21/01/2020

**Locomotive Workshop (Bays 1 - 4a) (SSD-8517-Mod-5)
Request for Additional Information**

C_STAGINGPLAN_4
CIVIL WORKS STAGING PLAN
DATE: 21/01/20
REVISION: 4

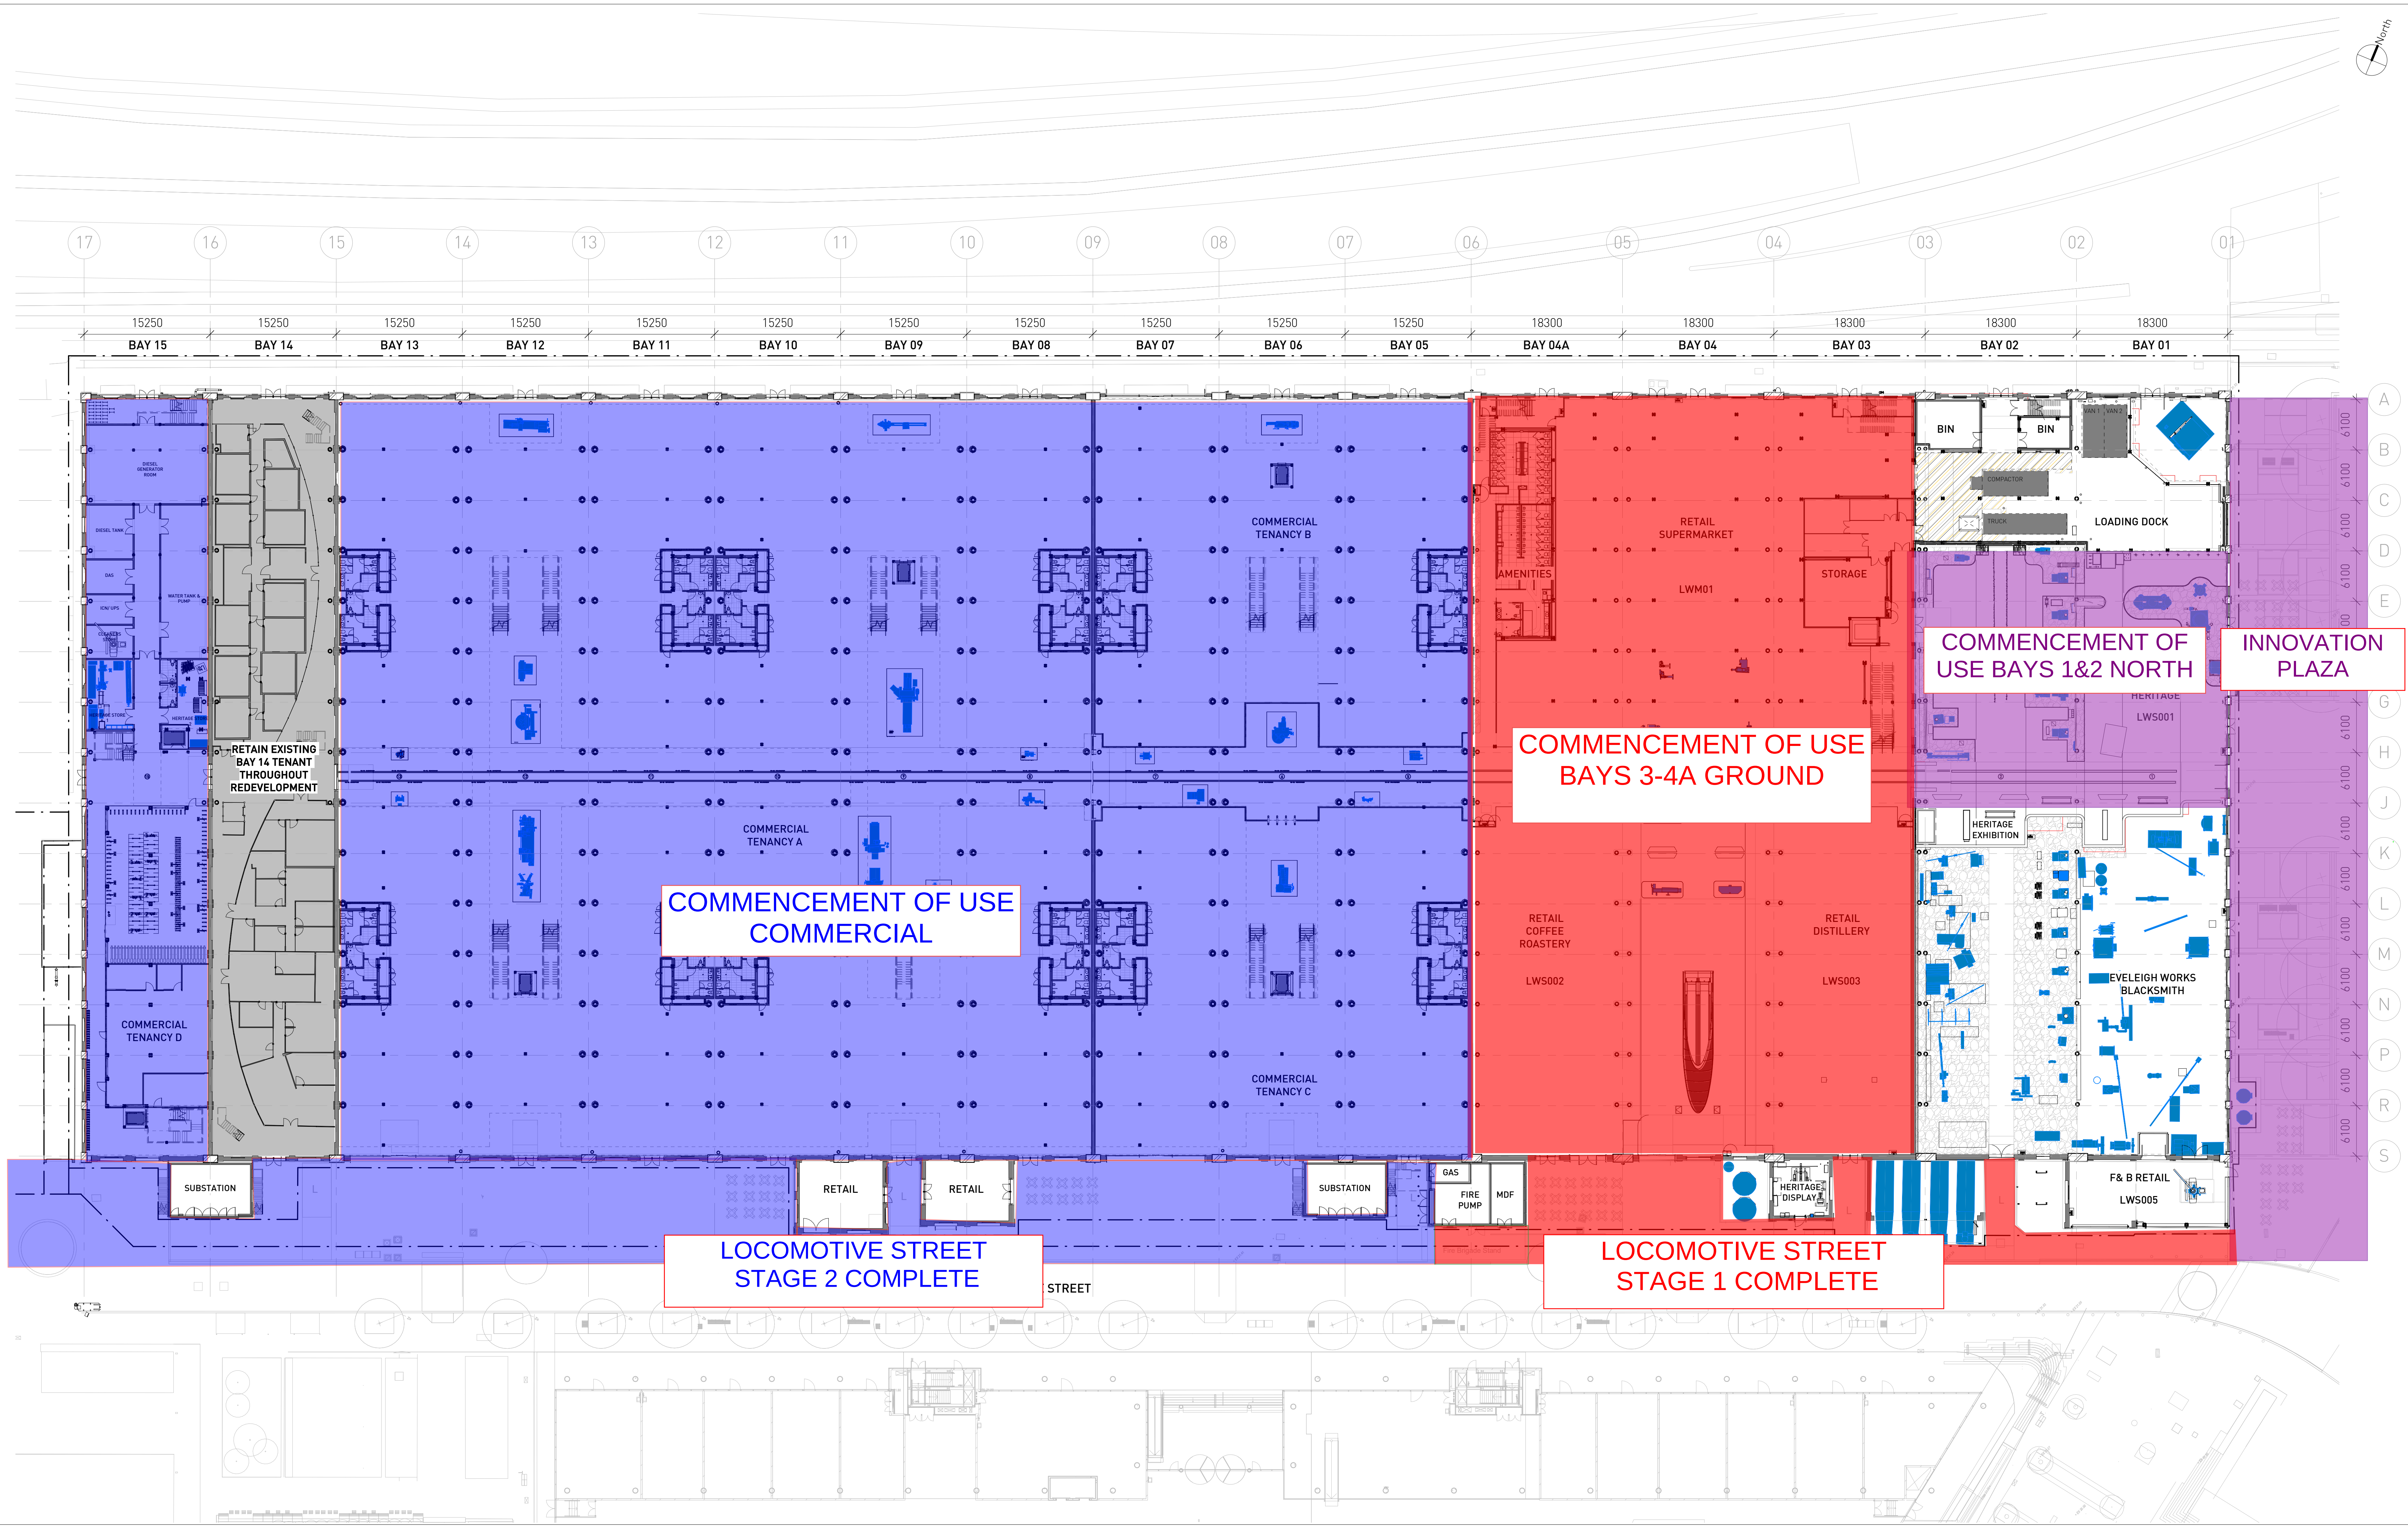
- Provide further justification for changes to the timing of conditions E19 and E20, specifically why the loading dock management plan and endorsement from Council's Local Pedestrian and Calming Committee are unable to be obtained prior to the issue of the first occupation certificate, as per the current wording of the condition.
- Provide an indicative timeframe for the commencement of the first use at the Locomotive Workshop and identify what this use will be.
- For the public domain staging plan submitted, update the drawing title block at the bottom of the page to include the title 'Civil Works Staging Plan' (as used in proposed wording of condition E9), and provide a drawing number, date and revision number to be included in the amended condition.
